Date: 21 April 2022

**Planning Application Ref.:** LA11/2021/1211/TBA  
**Location:** Between Station Road  
Lifford  
County Donegal and Strabane  
County Tyrone.

Proposed Riverine Pedestrian and Cycle Bridge at Station Road, Lifford, County Donegal - 11m in length between Lifford Co. Donegal and Strabane, County Tyrone.

**BRIDGE CONSTRUCTION PHASING WORKS - PHASE 1**

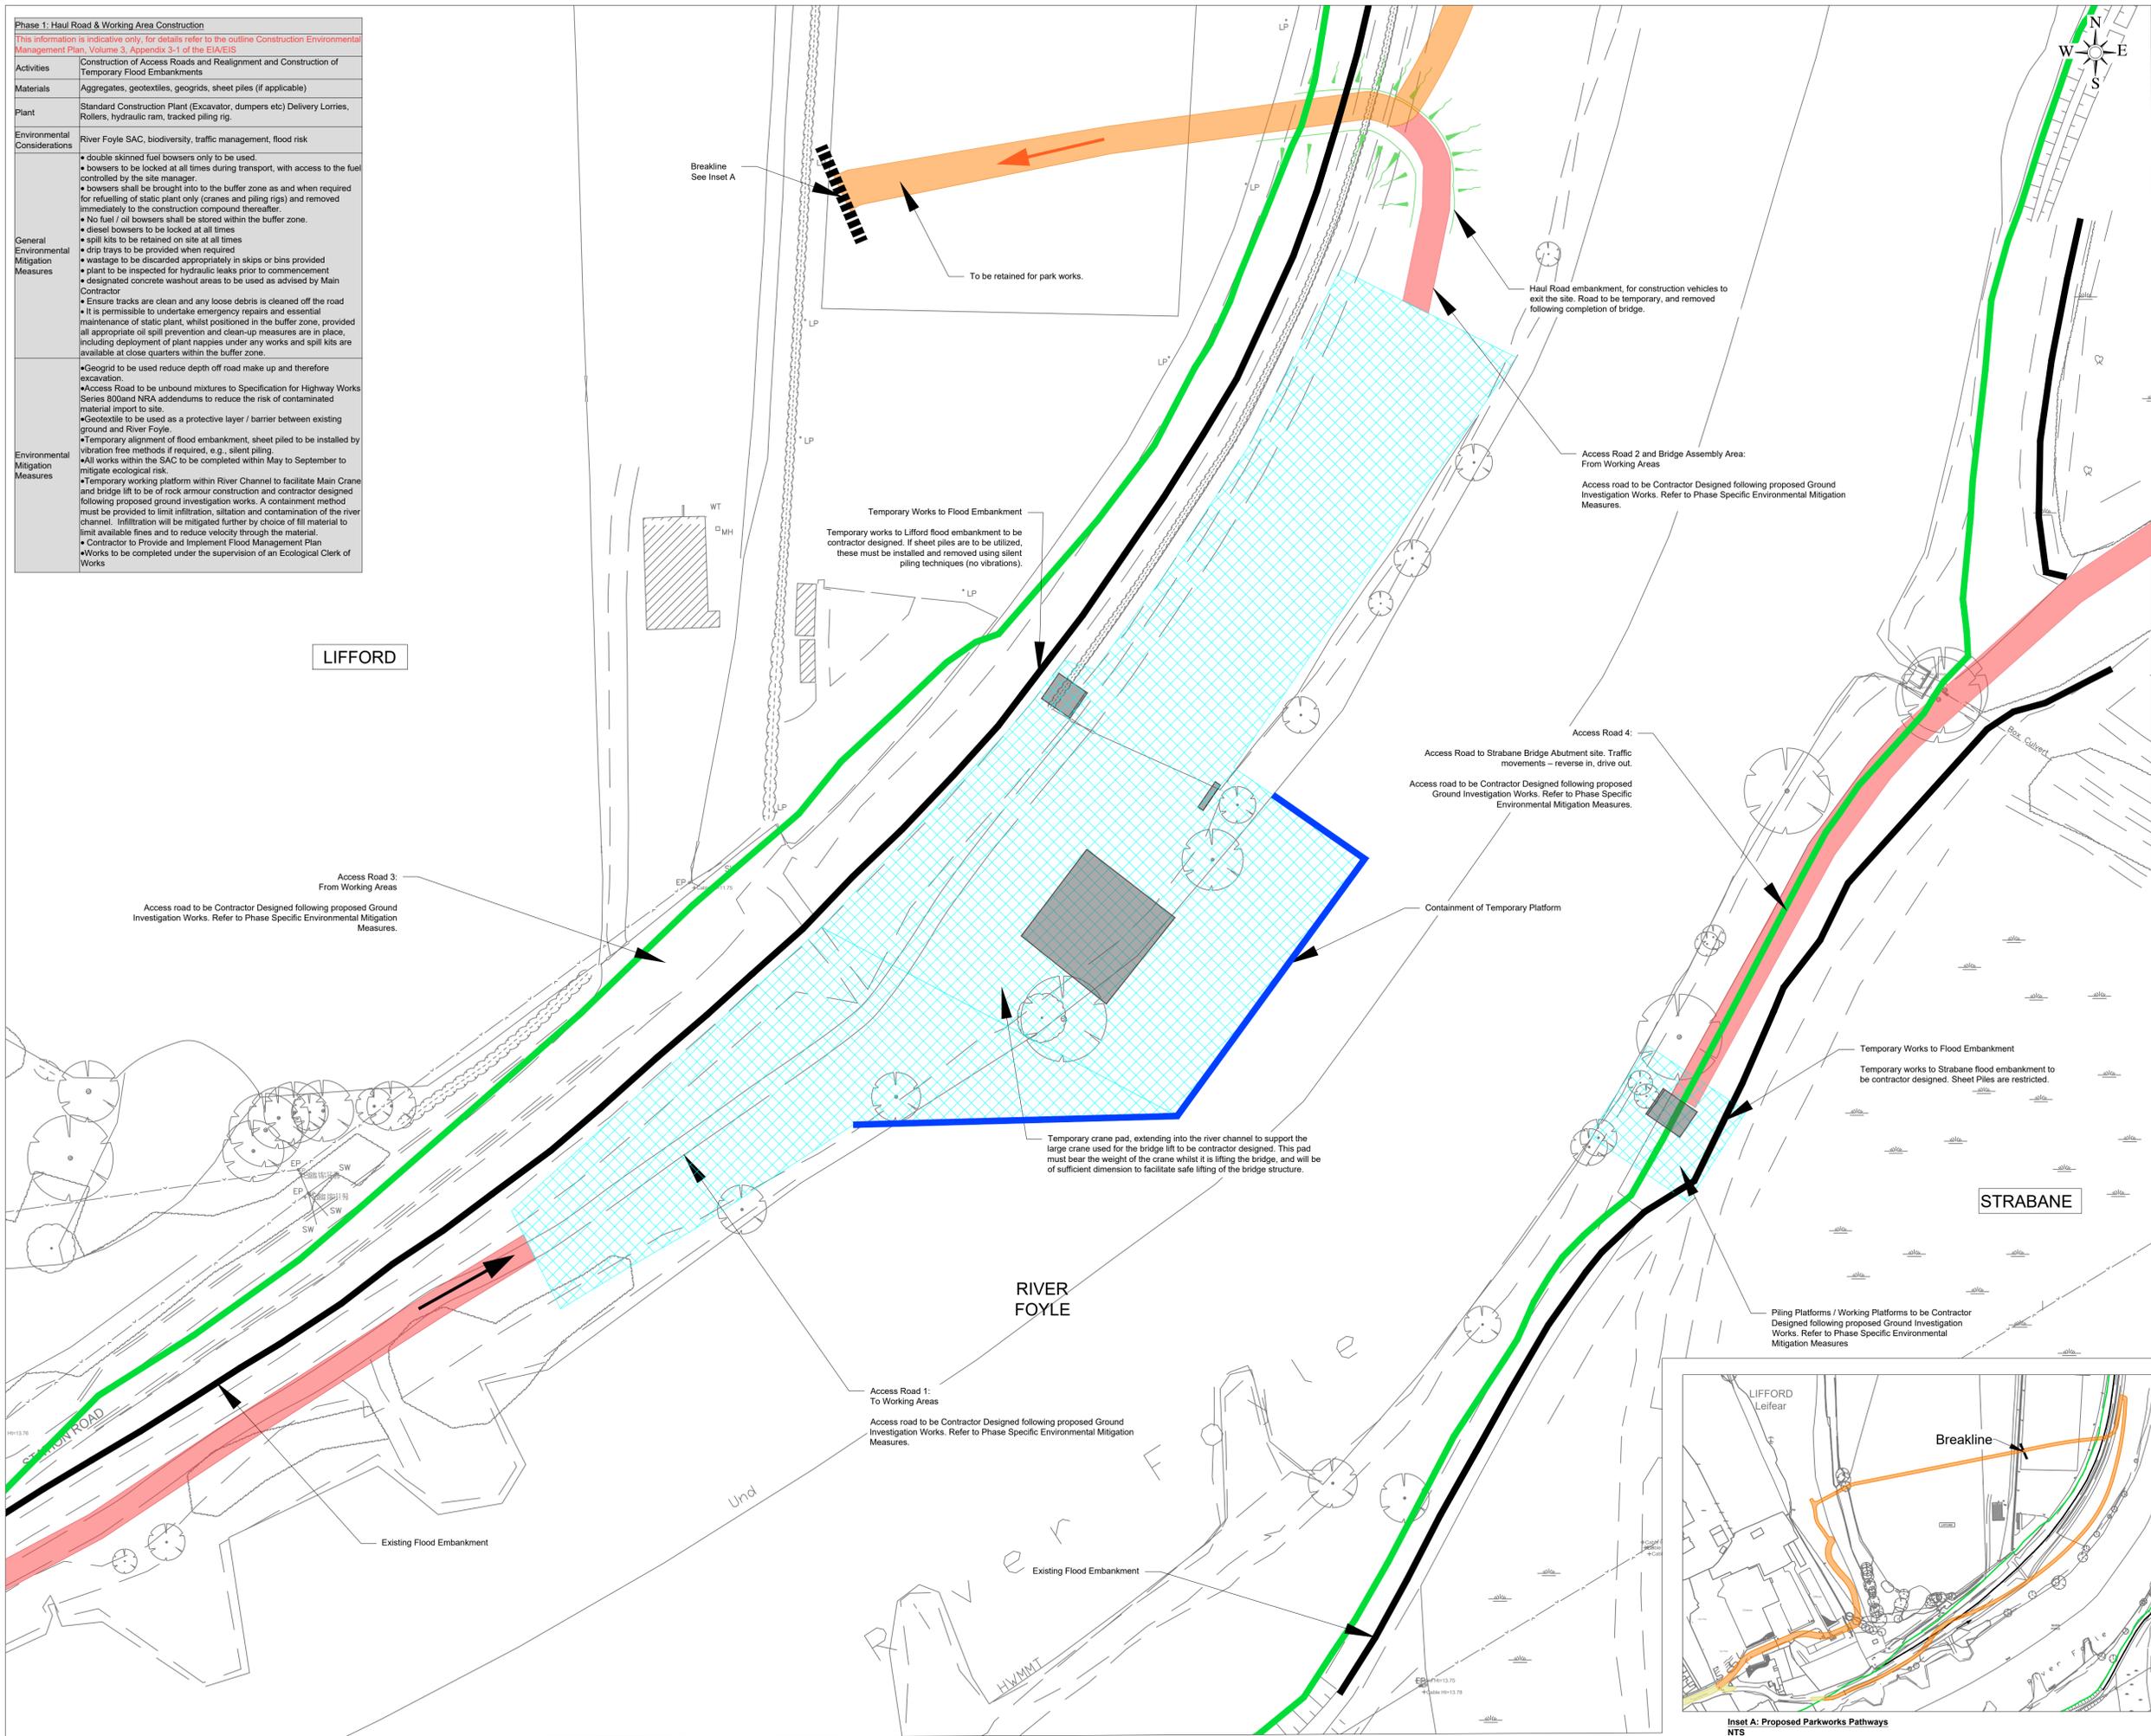
WMU note that the bridge construction phasing works documents make reference to double skinned fuel bowzers. These may not comply with the legislation WMU would direct the applicant to GPP2 Above ground oil storage tanks as and would seize opportunities to reinforce the importance of compliance with the Control of Pollution (Oil Storage) Regulations (NI) 2010. <http://www.legislation.gov.uk/nisr/2010/412/contents/made>
